**WEST SUSSEX COUNTY COUNCIL
PLANNING SERVICES CONSULTATION**

SUBJECT: A/3/18/PL - Change of use of land to storage (B8 Storage or Distribution), erection of barn & hardstanding (resubmission following A/111/17/PL).

Land at Arundel Road/A27, Angmering, BN16 4EU

Advice & Objection

Appendix A
Site Layout Plan

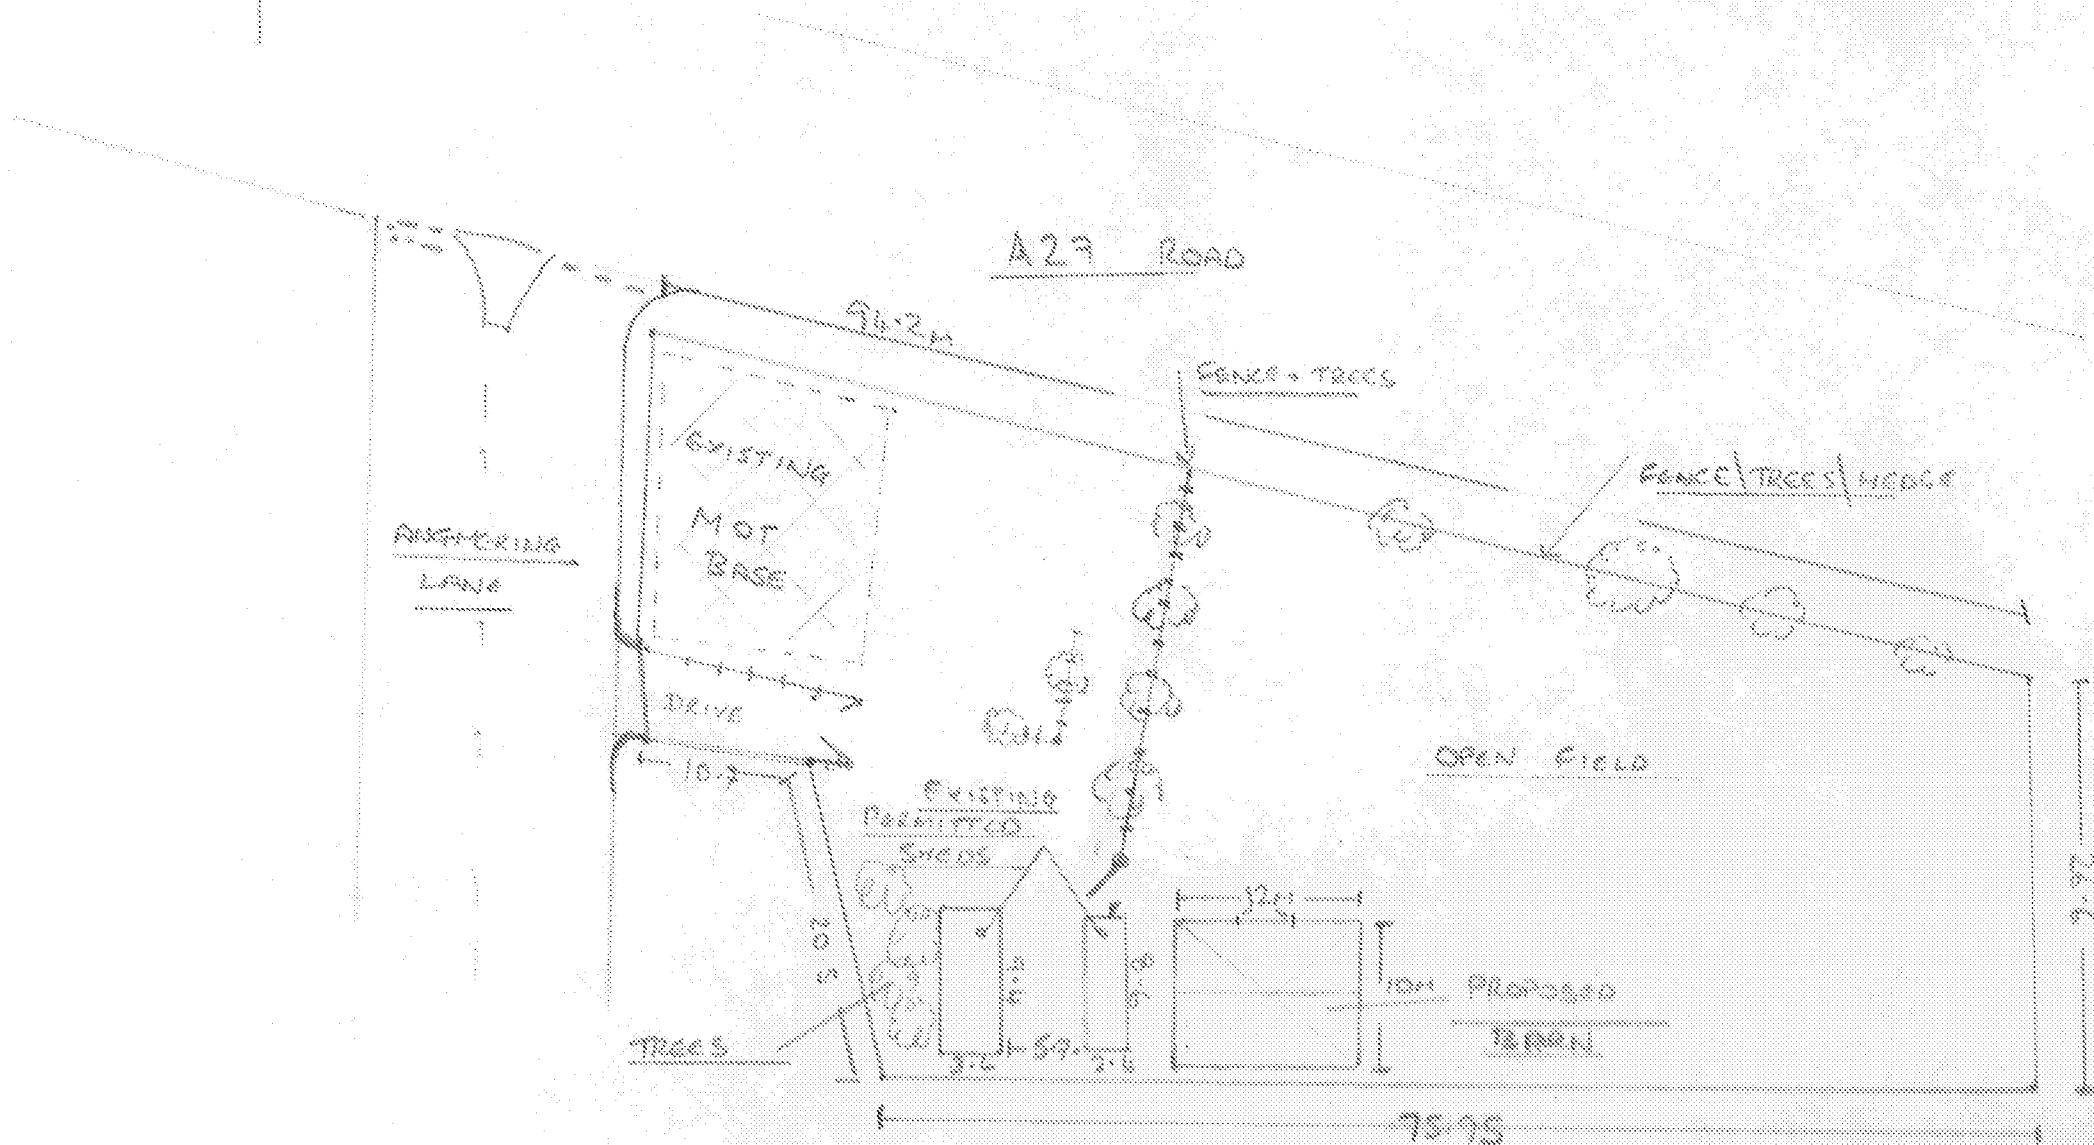
Previously on site several large trailers were observed. No evidence of ability for these to turn within the site was previously provided. The Technical Note provides swept path tracking for the turning of a car and caravan. While these plans themselves are acceptable, they do not represent the scenario of large HGV vehicles which could be associated with a B8 use class development.

Access Visibility Splays

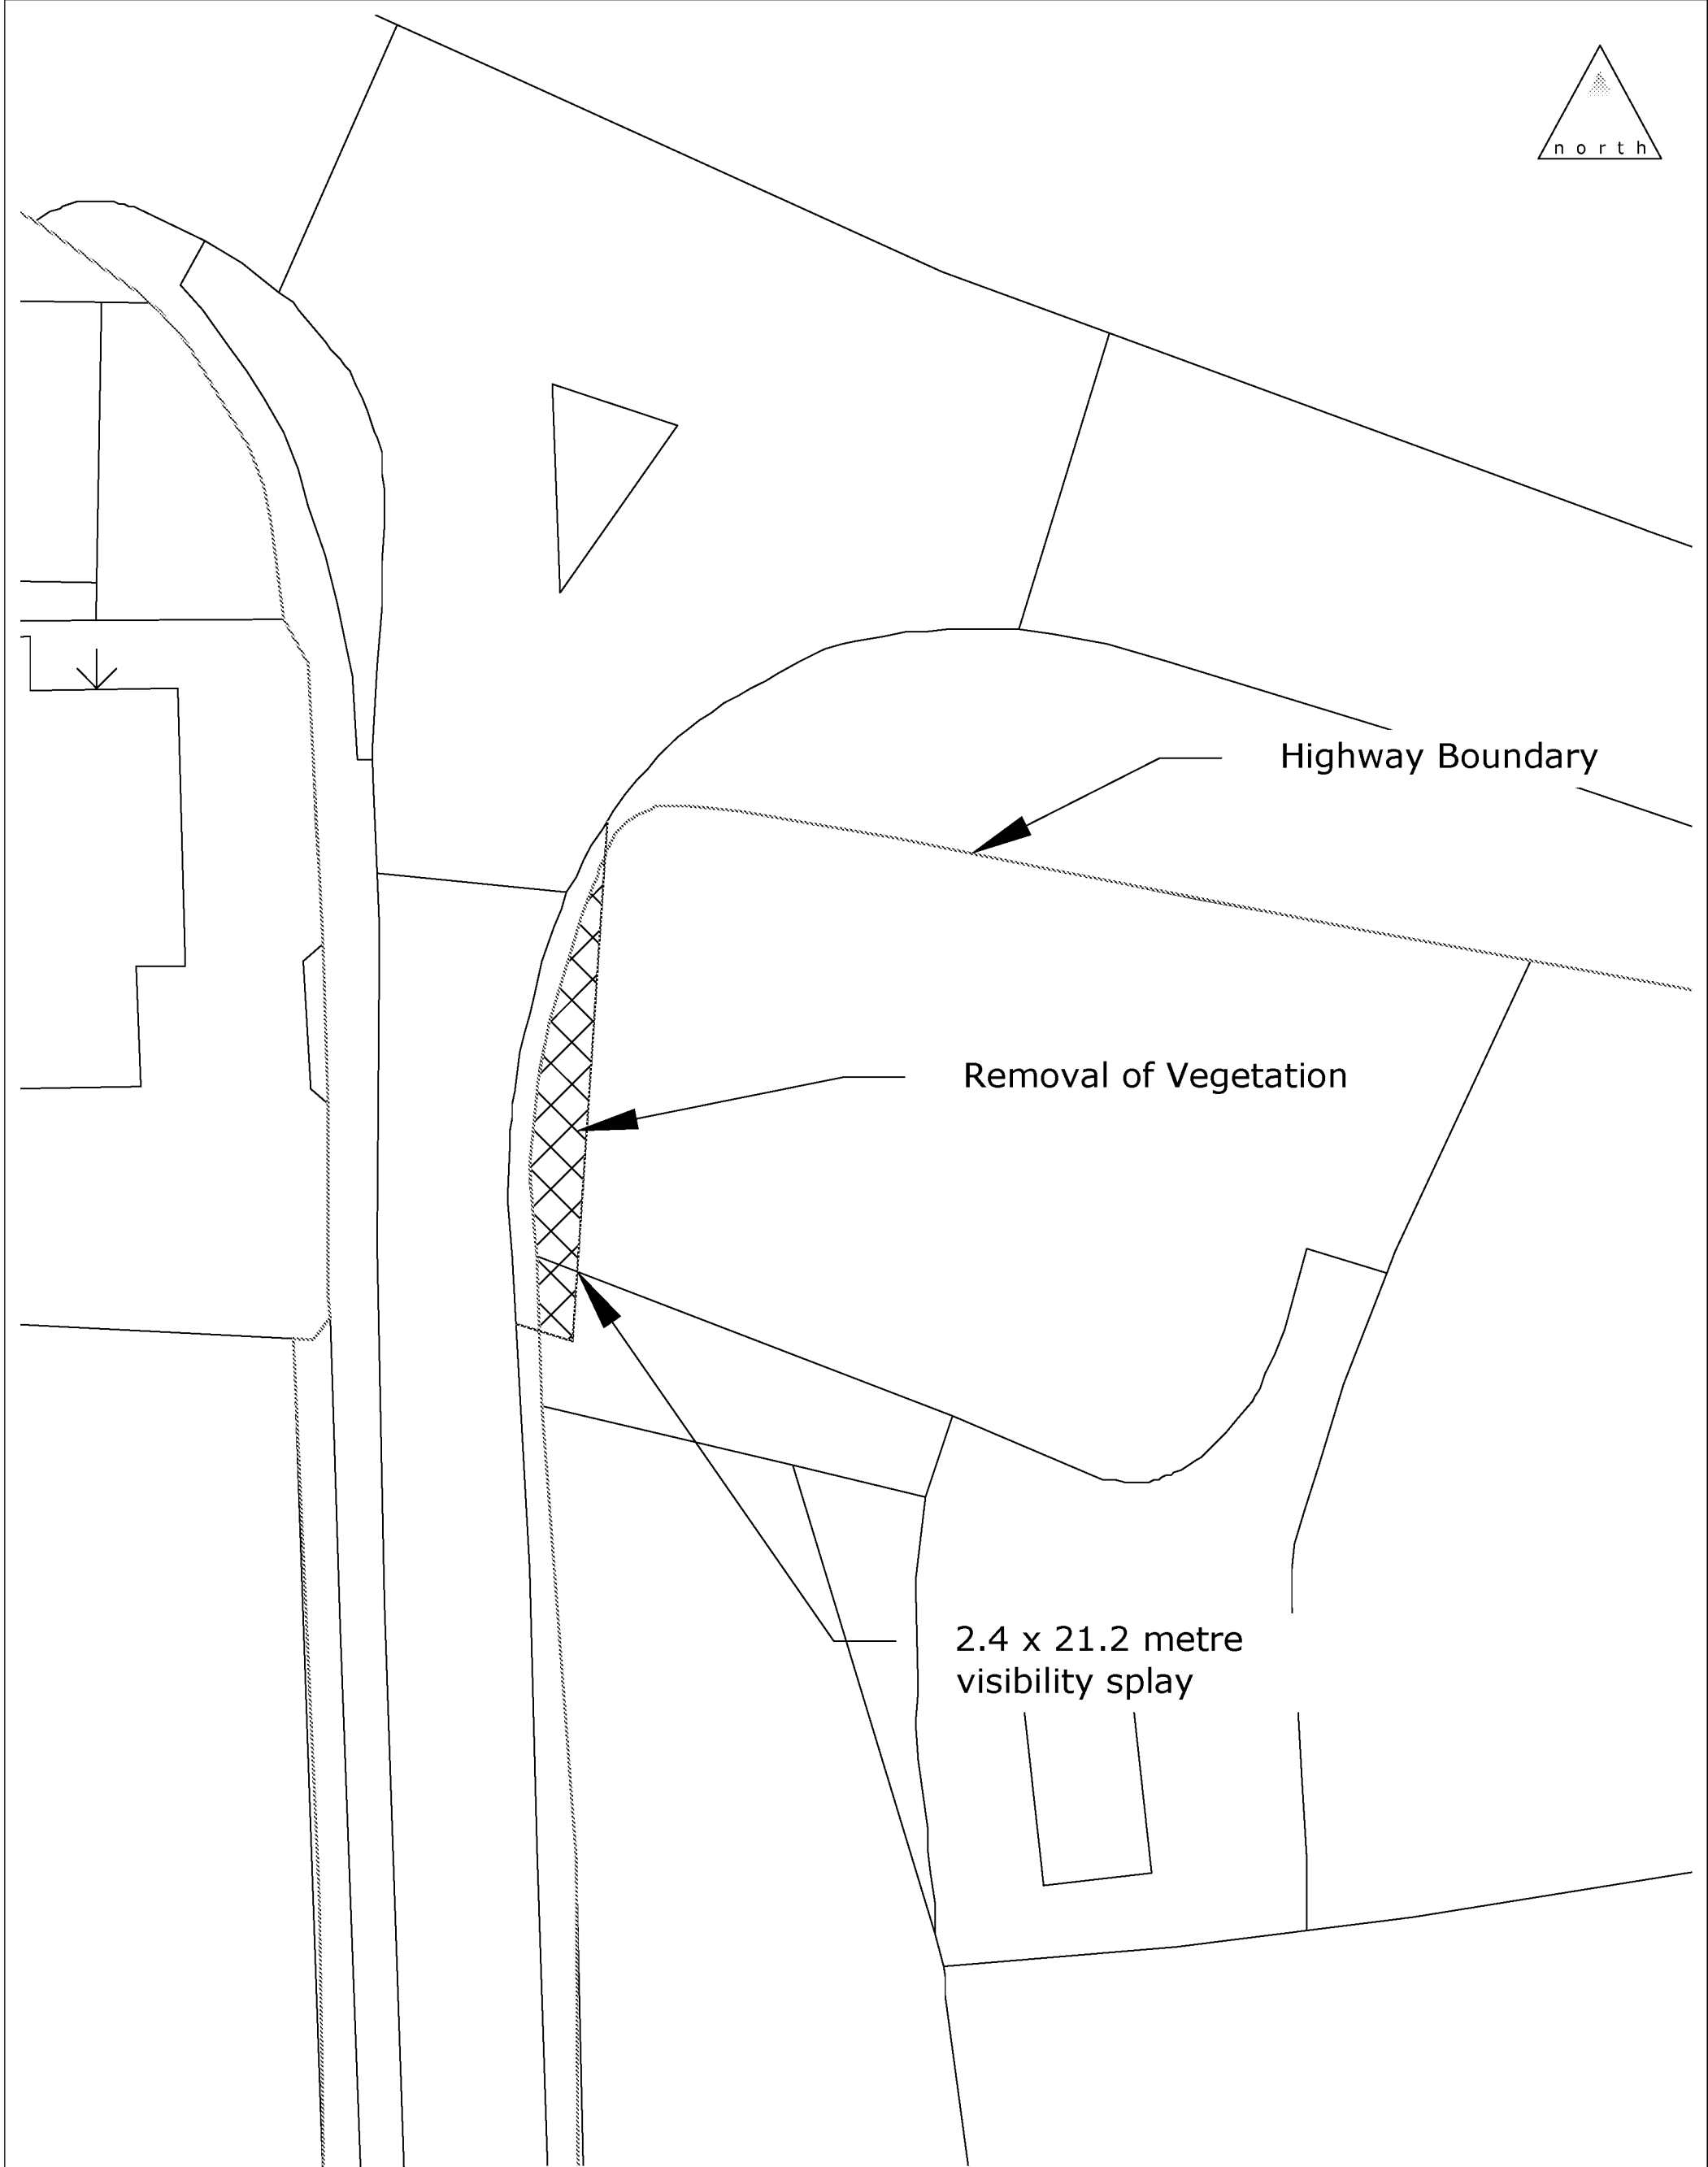
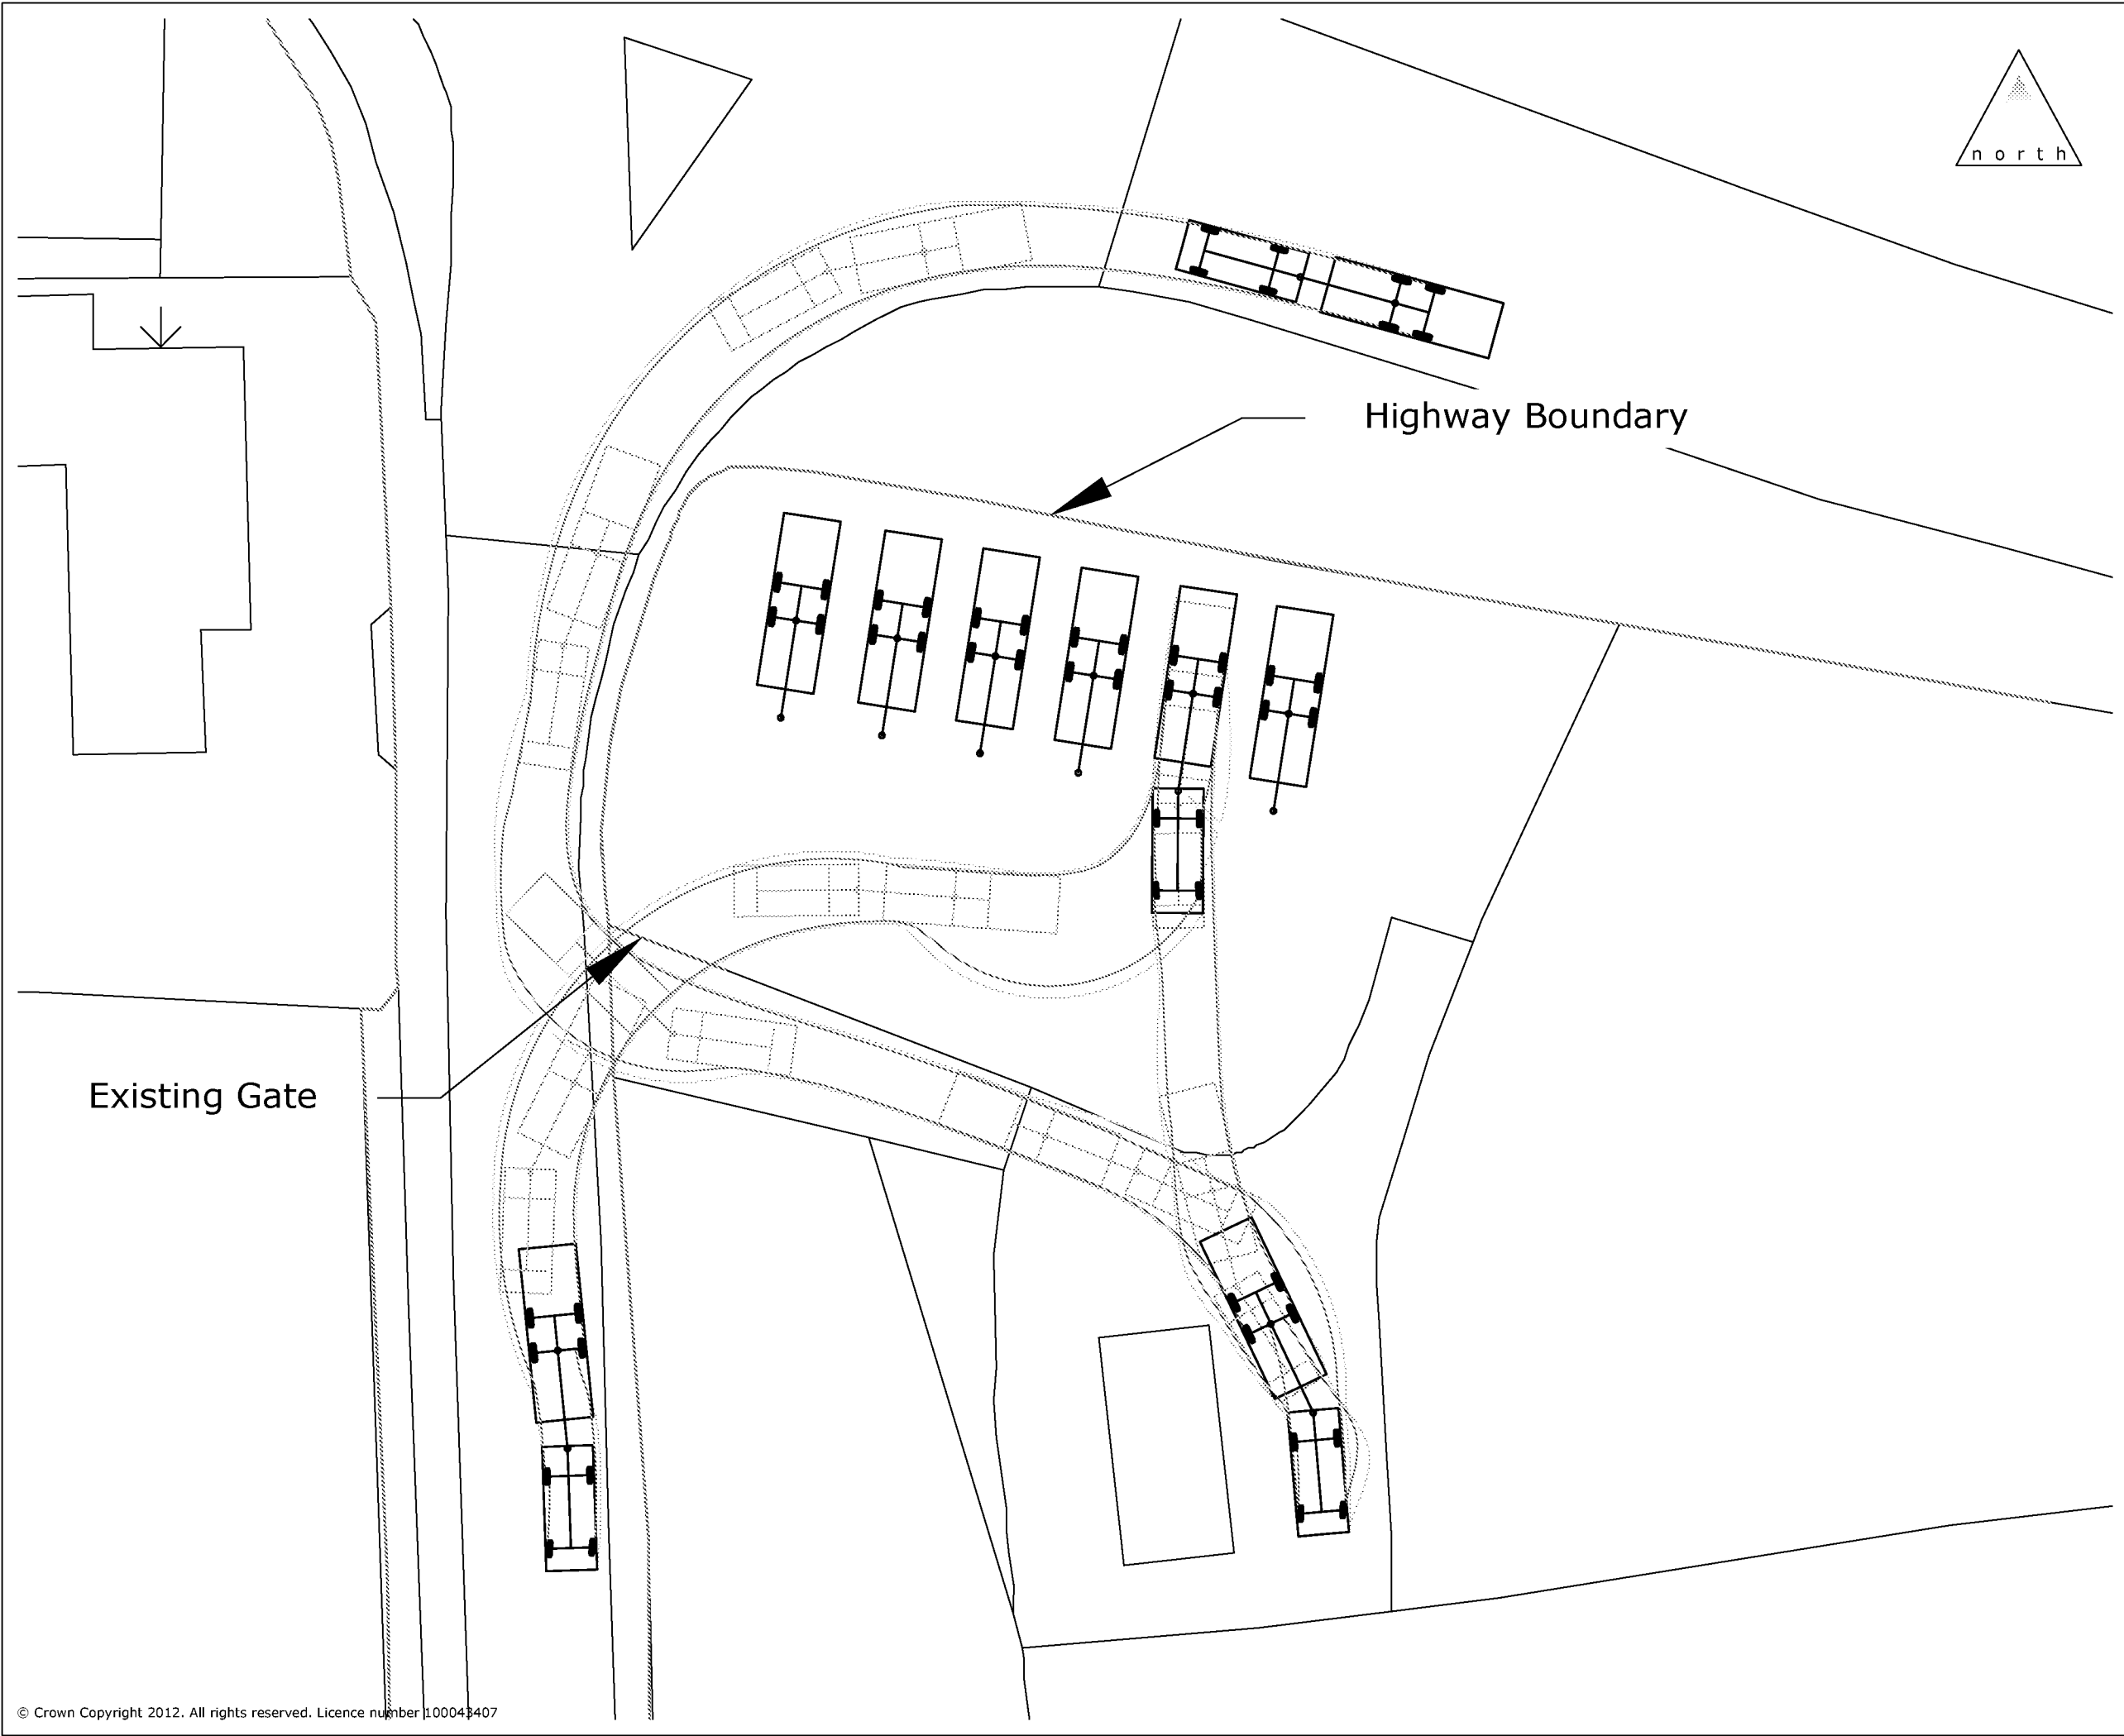
The Technical Note has satisfactorily demonstrated that such a splay of 2.4 x 21 metres is achievable and would be considered an improvement against the existing situation.

The Local Planning Authority would be advised that the formation of such a splay is going to have a significant impact upon the vegetation boundary in this location, and may require the removal a mature tree.

While it is appreciated that the applicant can improve visibility to the north in accordance with the Stopping Sight Distance requirements of the recorded road speeds it is questionable if the Planning Authority would be satisfied with other considerations involved in implementing this splay.
